Hwy 85-87 Academy Business Park

Landscape Development Plan

ACADEMY BLVD., COLORADO SPRINGS, CO

SHEET NO.
LS1
1 OF 4 SHEETS

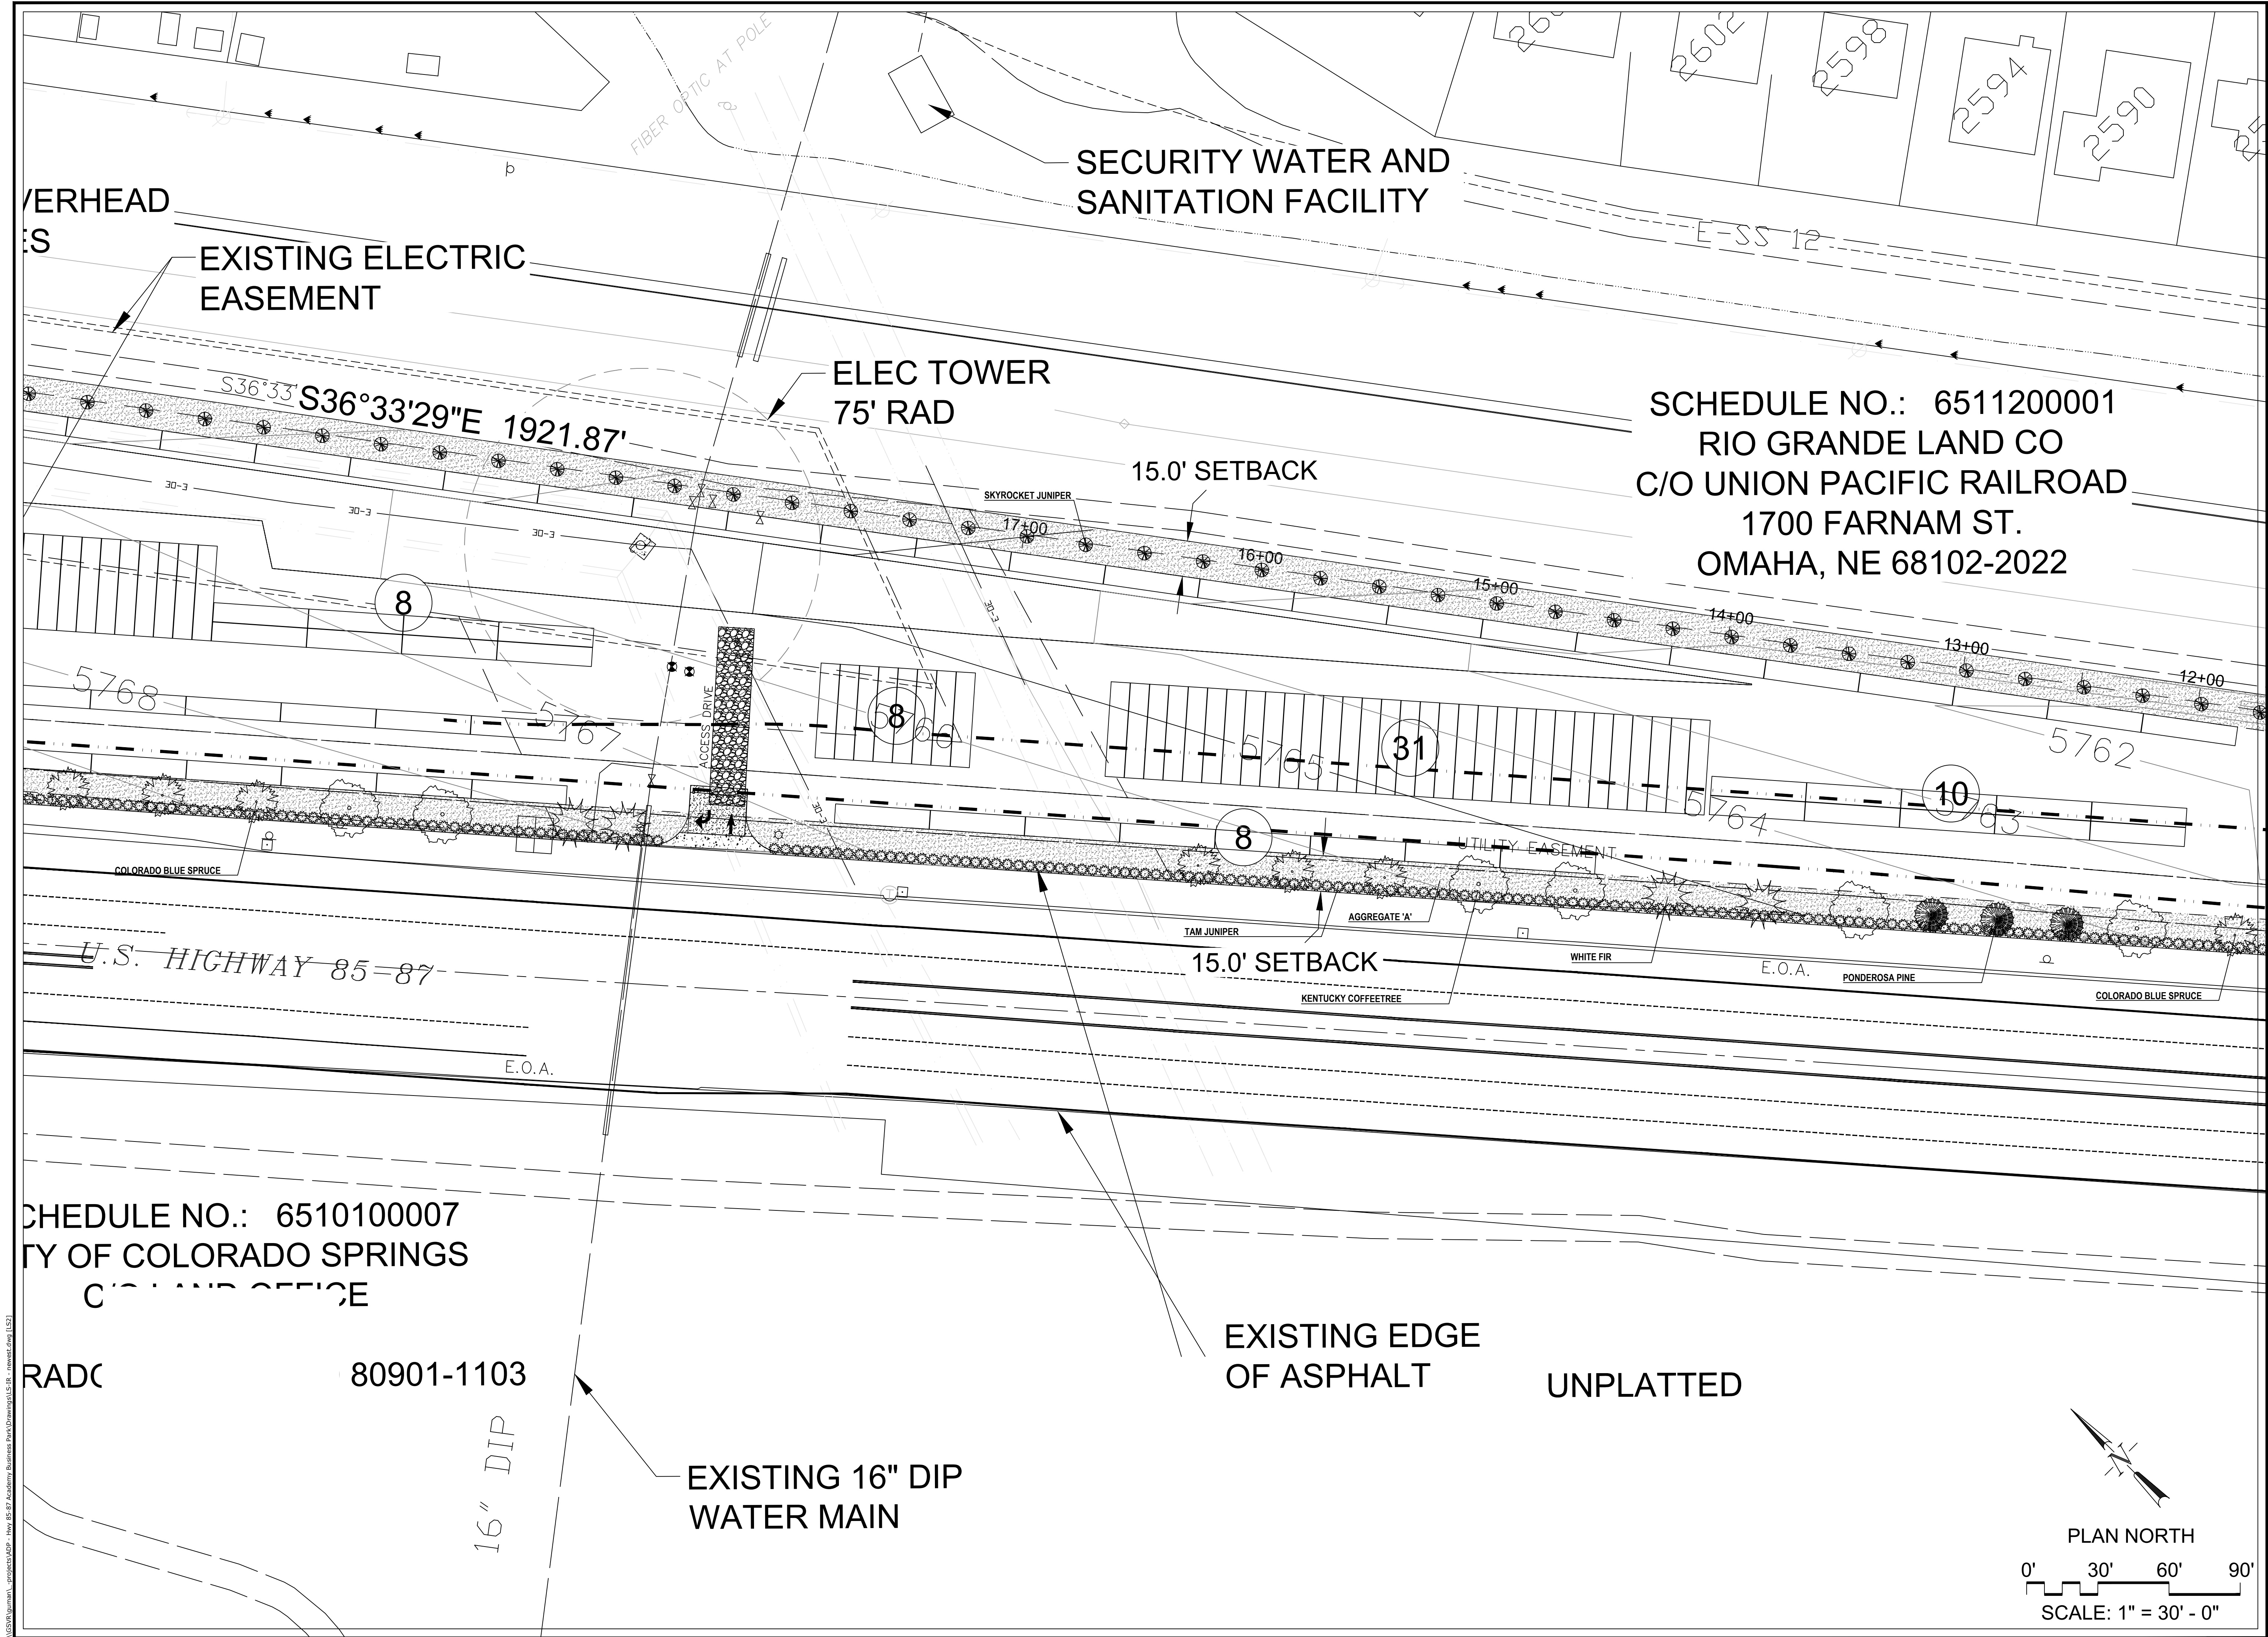
Per Land Development Code Section 6.2.2.D.2.iii : There shall be a 15 foot landscaping buffer on the residential side of the project

Per Land Development Code Section 6.2.2.D.2.iii :

There shall be a 15 foot landscaping buffer on the residential side of the project when use to use compatibility is a concern.
The minimum number of trees in the buffer shall be one tree for every 25 feet of common lot, parcel, or tract line. A minimum of 1/3 of the trees shall be evergreen trees.
An opaque fence or wall with a minimum height of 6 feet is required along the lot, parcel, or tract line. Bark, wood chips, rock, stone, or other natural landscape material shall be used as a non-living ground cover. Areas of a required buffer not covered in approved non-living ground cover material shall be covered in a living plant material.
